Re: 145 Marginal Way, Portland, Maine

Five Liver Company, owner at 145 Marginal Way in Portland, Maine, has reviewed the T|W Design drawings dated April 12, 2017, containing drawings originally issued June 27, 2017, with revision dates July 14, 2017, and related documents (collectively, the "Drawings"), all attached hereto.

**BK Planet Fitness renovation plan review notes :**

Sheet Number:  
**A1.2**

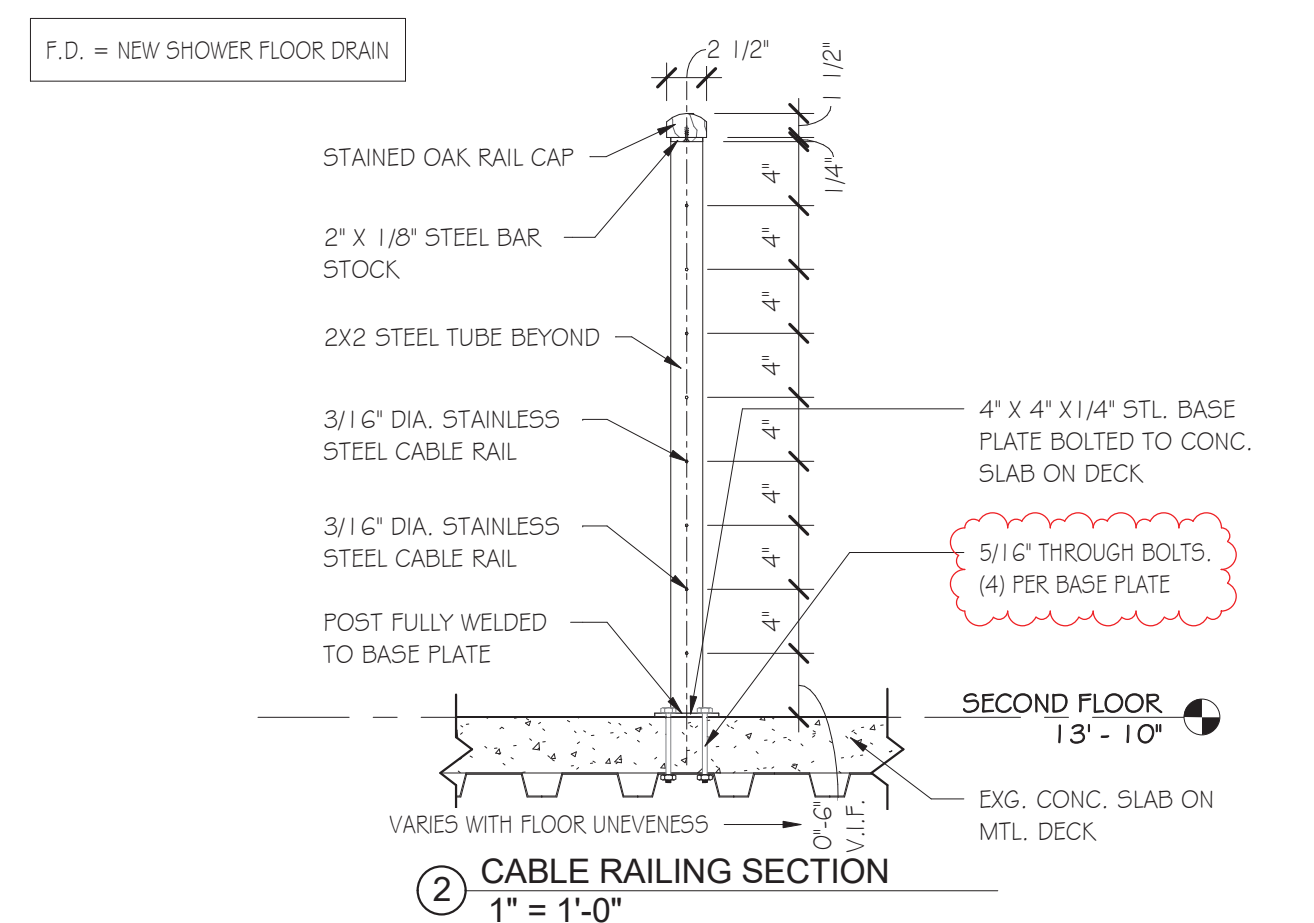
1. subject to the requirement that Tenant shall not cut, bore or trench "into or through any floor, roof or building structure" without prior separate written consent from Landlord (rather than only "through" the same, as stated on page 1 of TW Design's attached plans), and
2. subject to the additional requirement that subject to structural review: The second floor concrete slab & metal decking may be drilled to install railing per detail 2/A1.2, but that Tenant shall not drill into or through any structural steel (rather than only "through the same) without prior separate written consent from Landlord.
